re : **REFERENCE AB/7/14**

33 MALTRAVERS STREET, ARUNDEL BN18 9BU

I write to put you on notice and seek clarification reference the above application and its effect on my Client's property more particularly as follows.

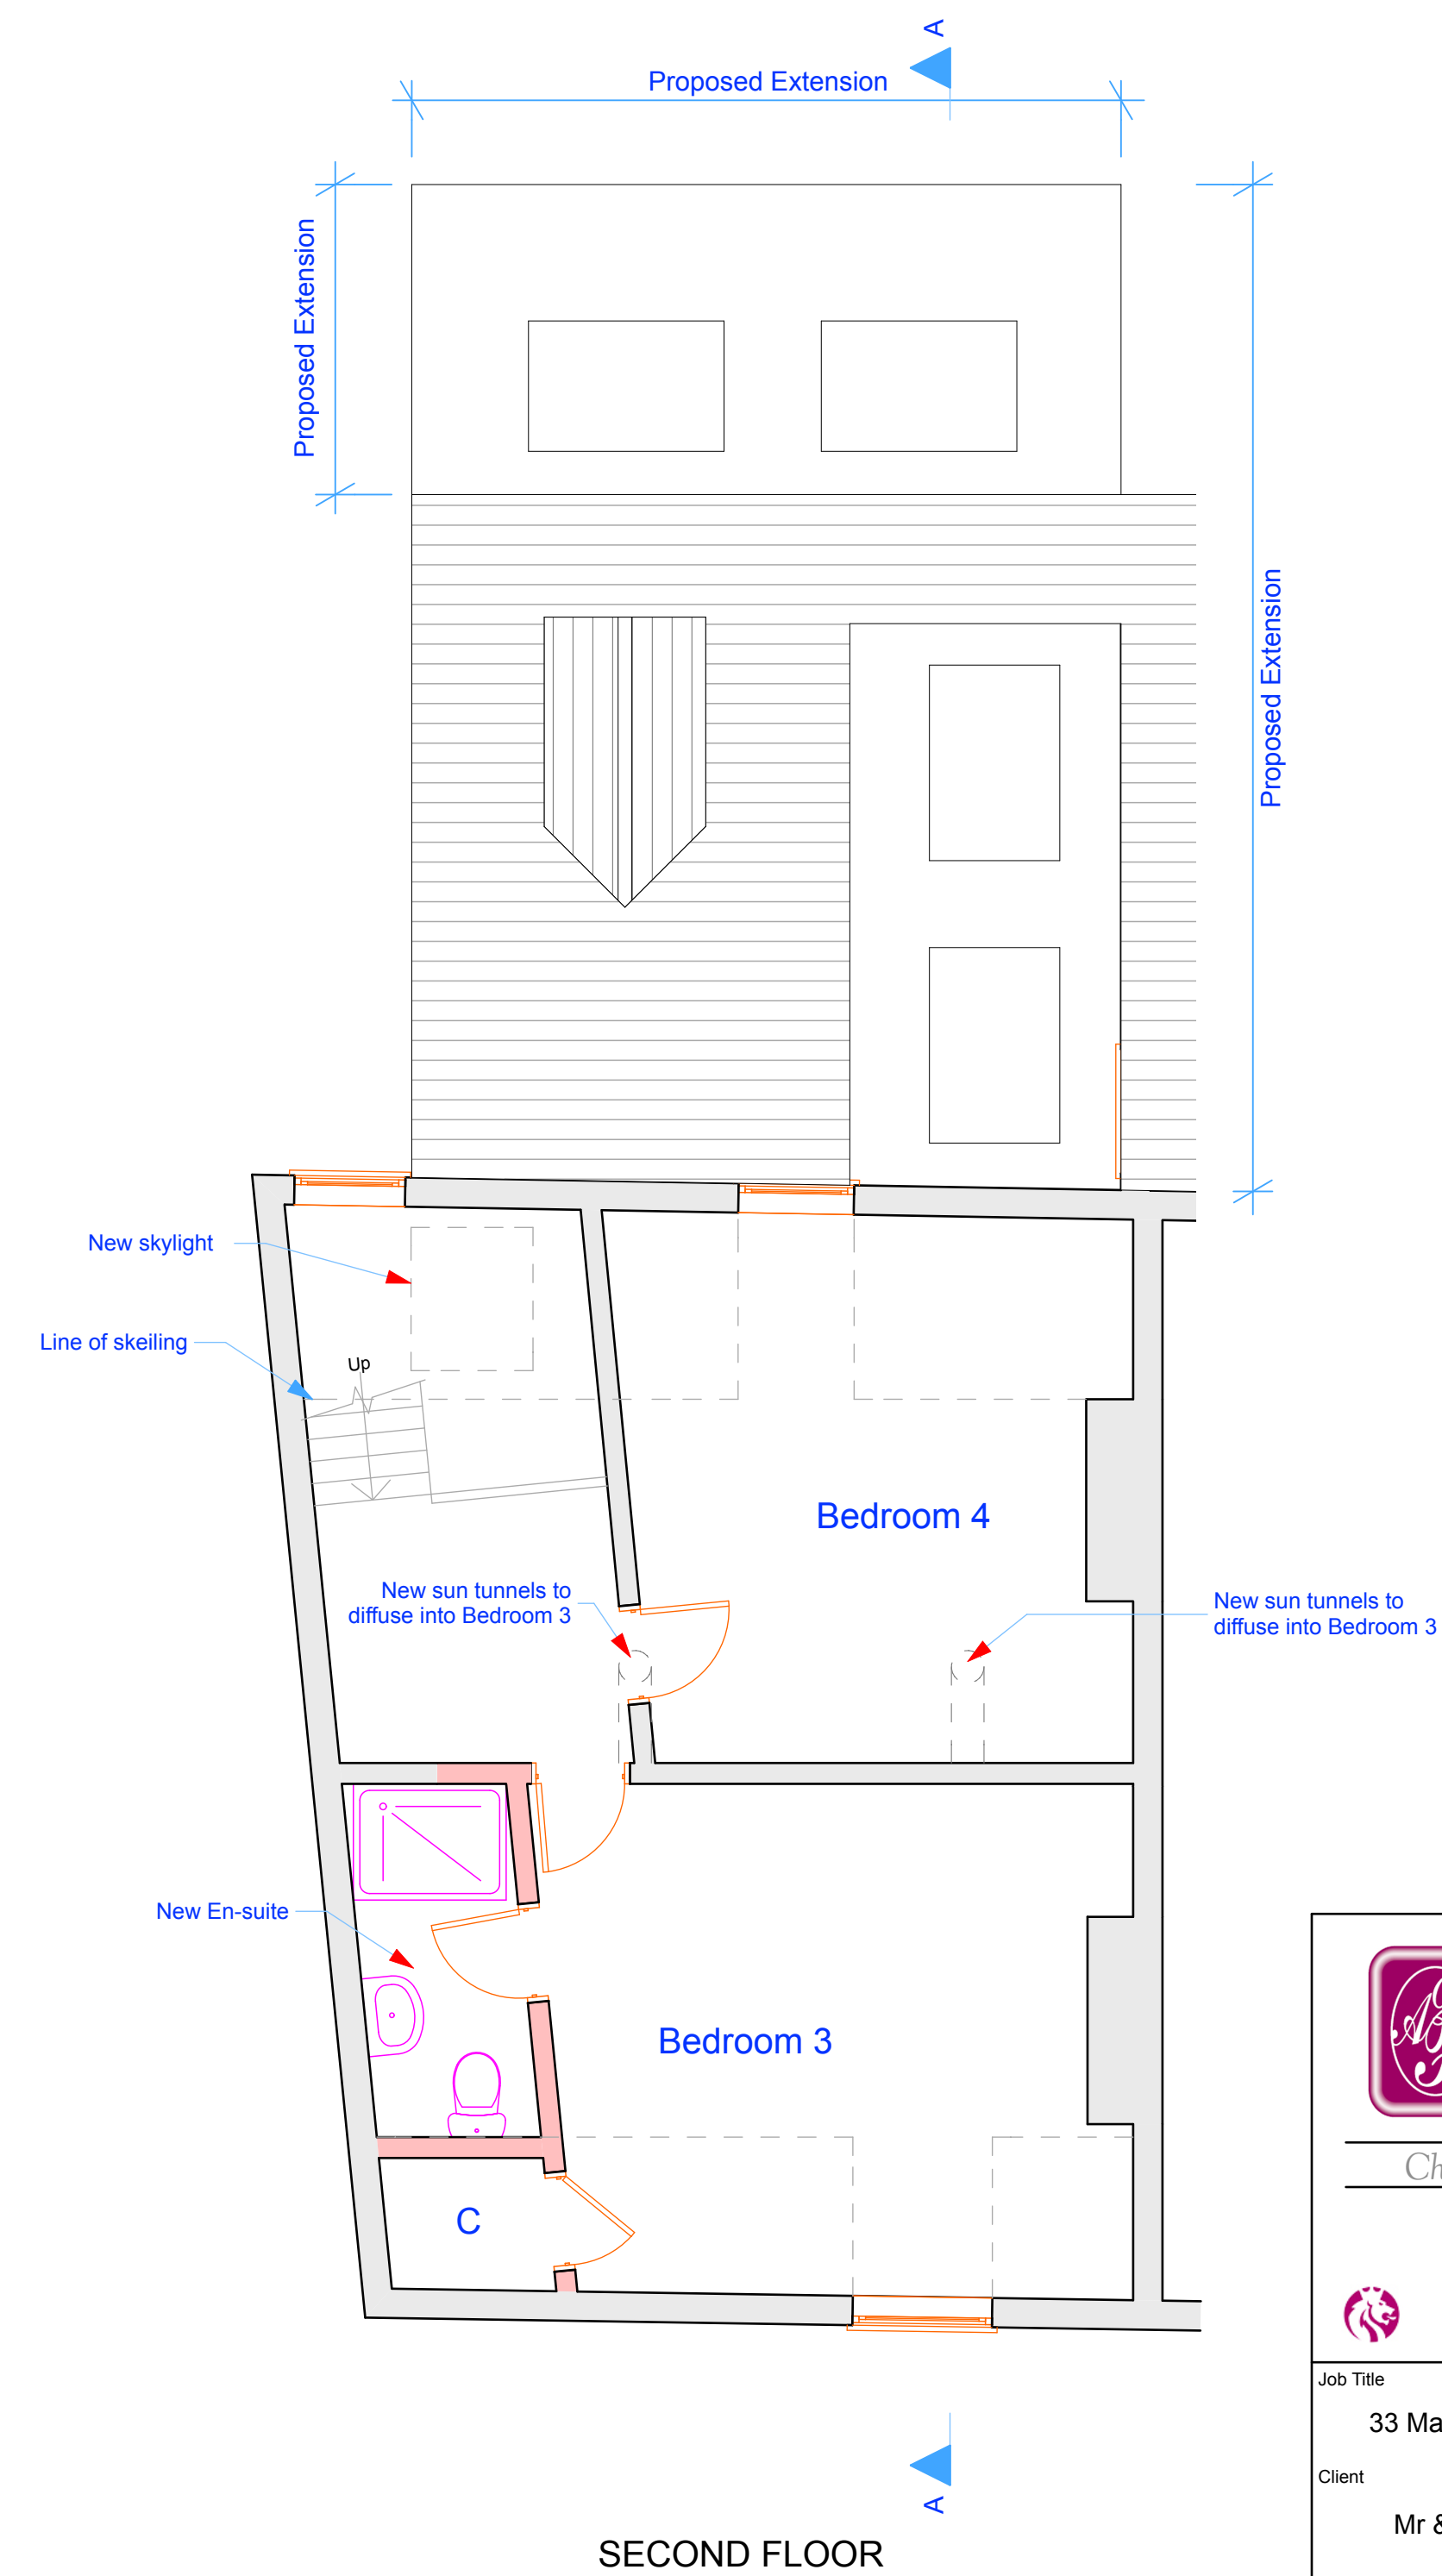
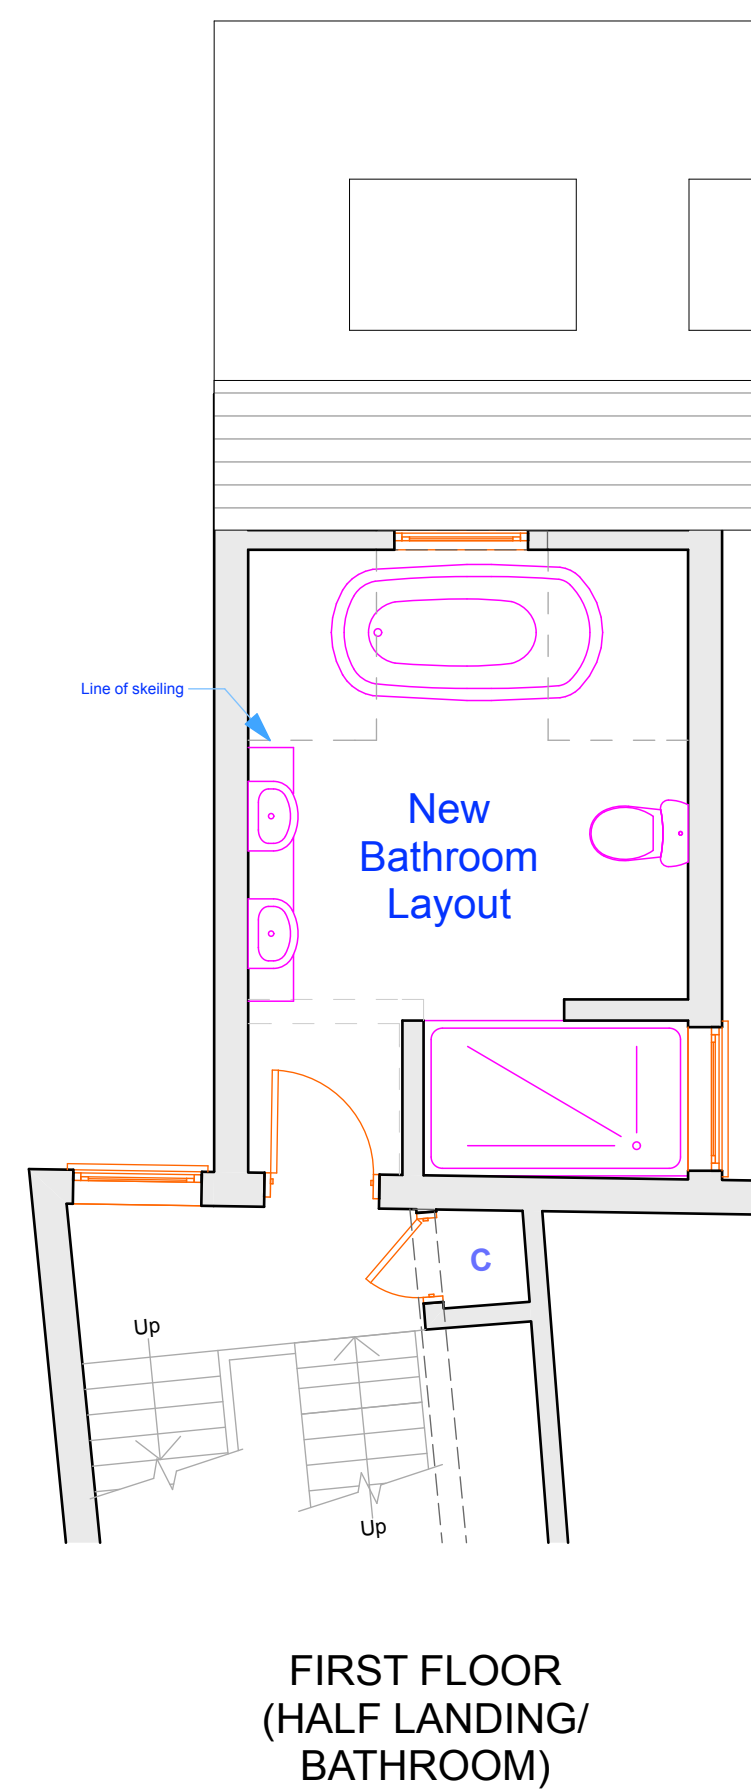
The proposed plans for the alterations to 33 Maltravers Street indicate that the existing kitchen window within the rear flank wall of the adjoining property, 35 Maltravers Street, is to be fully enclosed by the new kitchen/breakfast room. The plans stating "obscure glaze or glass brick in neighbouring window".

On behalf of my Client, Mr Eddowes, I would ask that you give due consideration to this proposal and the adverse effect that it will have on my Client's property creating loss of natural light and ventilation.
